East Anglia One North (EA1N) and East Anglia Two (EA2) Offshore Wind Farms

Planning Inspectorate Reference: EA1N – EN010077, EA2 – EN010078

Deadline 5 – 3 February 2021

Comments of Suffolk County Council as Lead Local Flood Authority

TYPICAL INFILTRATION BASIN CROSS SECTION

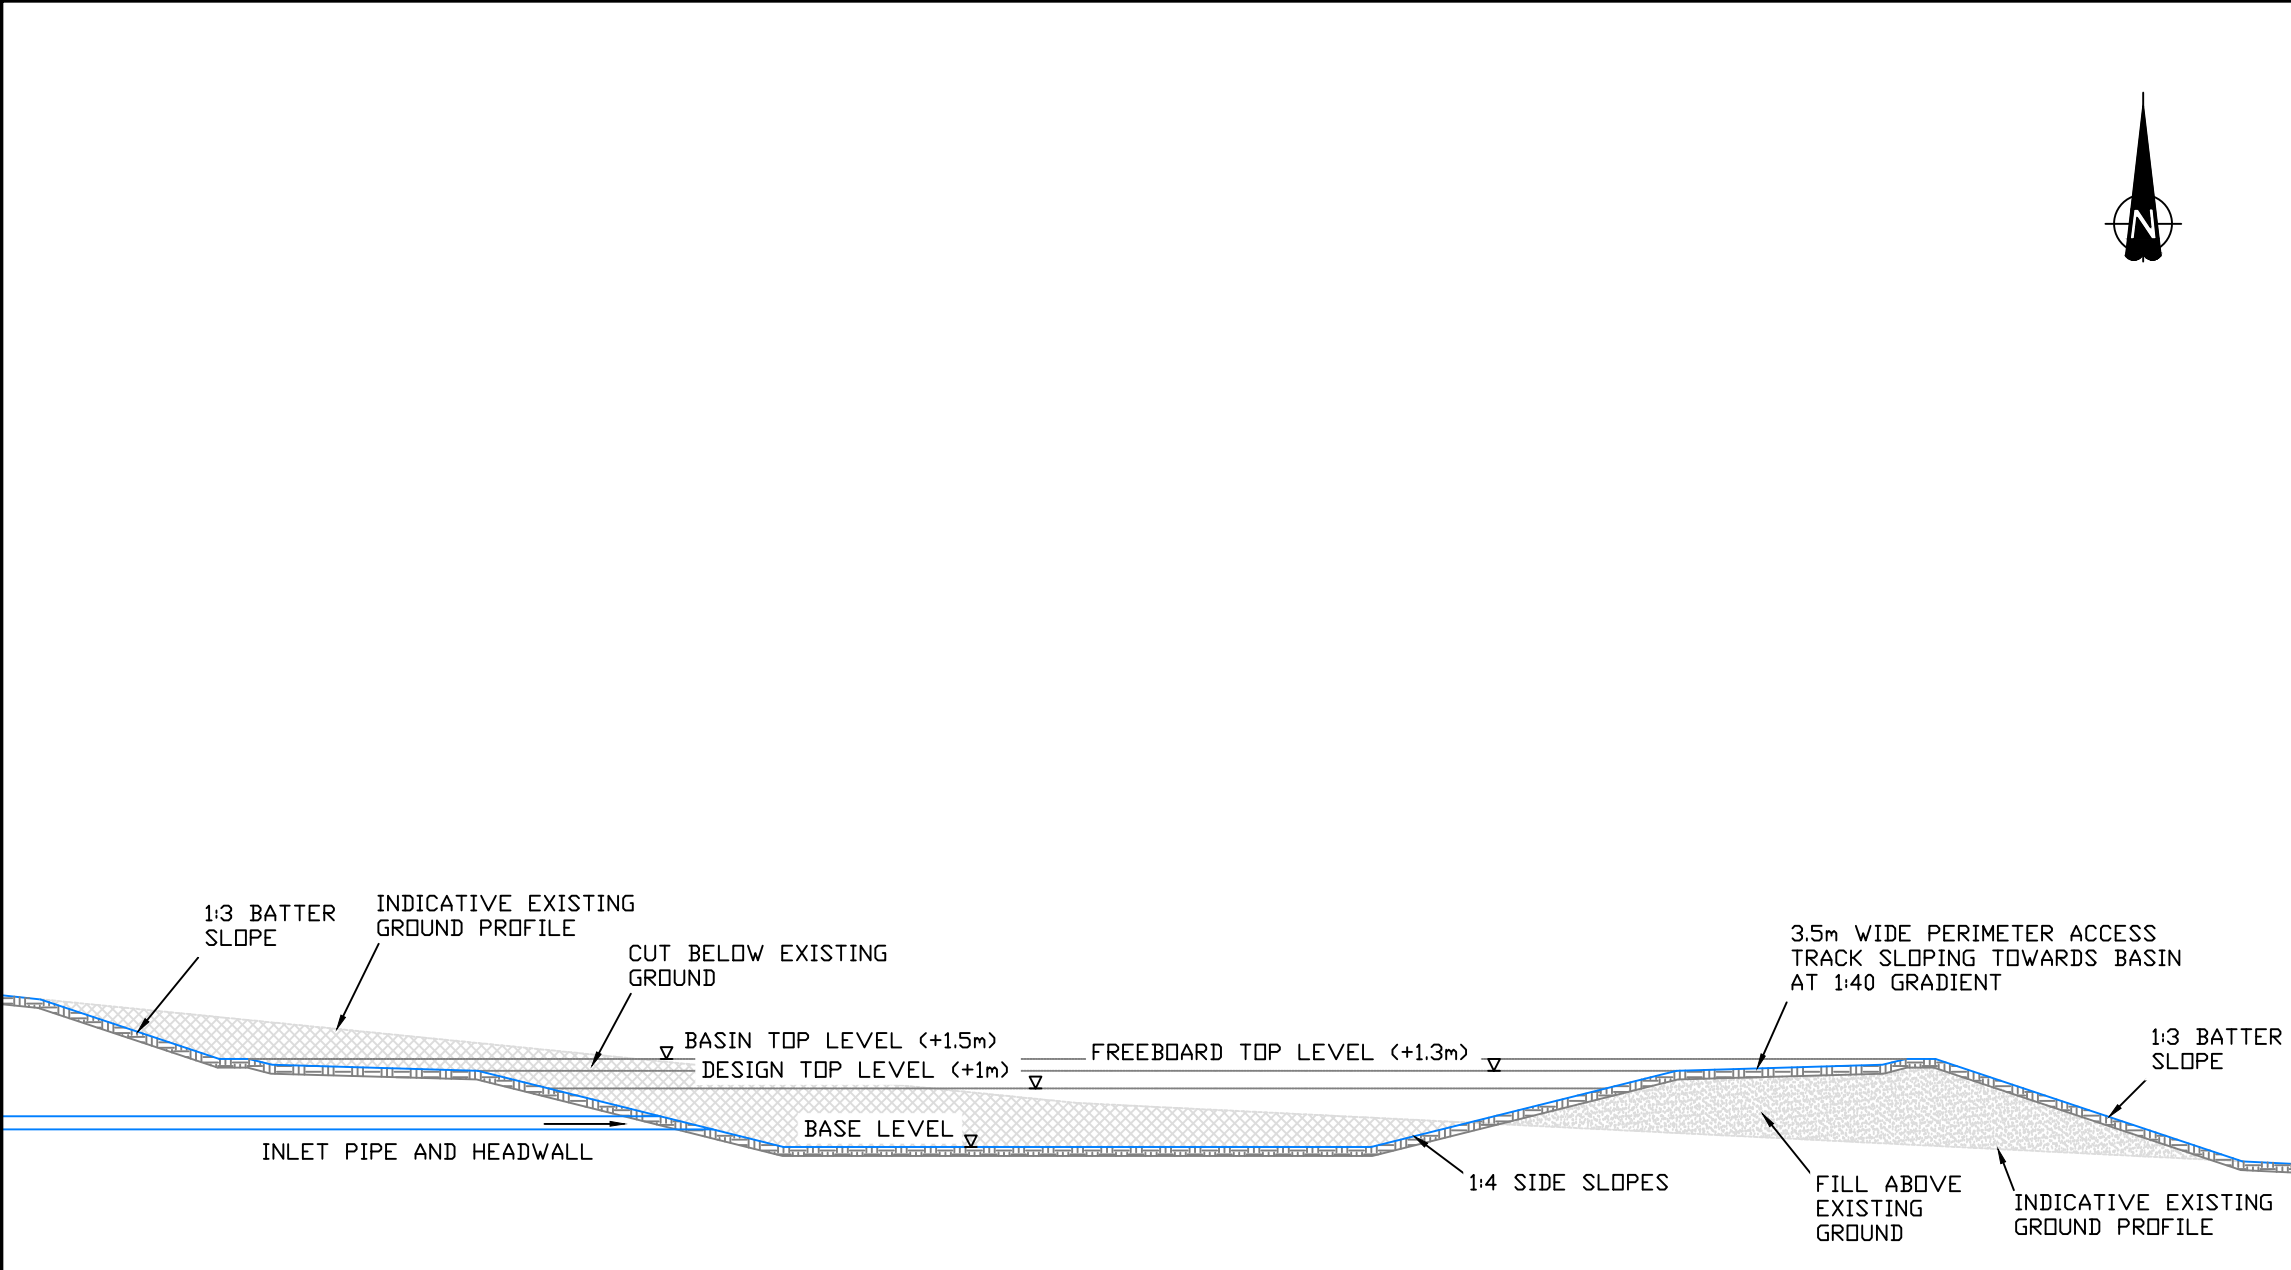
On the face of it, sufficient storage is provided for 1:100+20%, however flooded volumes of 2639.55m³ are identified for the 1:100+40% event. For context, an Olympic swimming pool has a volume of 2500m³ (Ref 18). These flooded volumes are not evaluated and thus our assumption is the proposal is for them not to be contained. Given the natural topography, these flows would be directed towards Friston, resulting in a significant increase in surface water flood risk.

However, the Applicants assessment that there is sufficient storage for 1:100+20% is incorrect. This event only has sufficient storage by utilising storage volumes provided by freeboard and the perimeter access track. This is not acceptable. CIRIA SuDS Manual defines freeboard as *“Distance between the design water level and the top of a structure, provided as a precautionary safety measure against early system failure”* (Ref 7, pg 783). Therefore, freeboard cannot be used for the design storm event and the perimeter access track above the freeboard level certainly cannot be used either. On this basis, using the figures provided in Appendix 2 of the Outline Operational Drainage Management Plan, the design storage volumes provided by the basins are as per the below table:

Comparing the two above tables (duplicated from Appendix 2 of the Outline Operational Drainage Management Plan), it is evident there is a significant shortfall in surface water attenuation volumes provided by the Projects which results in a significant increase in surface water flood risk.

Using the calculations from Appendix 2 of the Outline Operational Drainage Management Plan, cumulatively the basins design storage volumes would be exceeded by 5,402m³ during the 1:100+20% event and 8976.9m³ during the 1:100+40% event, as set out in the below table, produced by SCC:

<p>No assessment has been undertaken of ability of the proposed basins to deliver Interception (5mm of rainfall across the site (Ref 7, pg 527)). Whilst this would usually be considered a detailed design element, given the existing catchment does not generate runoff to Friston Main River during small rainfall events, the proposed system must mimic this. If current proposals do not deliver Interception, the only way to facilitate this is with an increase in plan area, hence, it must be considered now.</p> <p>No calculations or plans have been provided to support the information contained within Appendix 2. The Applicants statement at ISH4 that these are available is acknowledged and SCC encourage submission of this information, although we query why this has not been previously submitted if readily available.</p>
<p>iii. Existing conditions</p>	<p>To date, no ground investigations (boreholes, infiltration testing or groundwater monitoring) have been undertaken at the location of the proposed substation sites. As such, only high level, publicly available information, such as British Geological Survey mapping, is used to assess existing soil conditions at the locations of the proposed infiltration/attenuation basins.</p> <p>Multiple ordinary watercourses and a flood storage basin (which discharges via. infiltration) serve the existing catchment north of Friston. Surface water is intercepted by these features during minor rainfall events, resulting in minimal, if any, runoff entering the Friston Main River. When the catchment is saturated water flows through the watercourse network, discharging as overland flow along a track that runs north south towards Church Road, Friston, at which point overland flows enter the Friston Main River.</p> <p>Multiple land drains also discharge into a large wooded pit in the centre of the site, again infiltrating water. However, the extent of land served by these land drains is not known.</p>
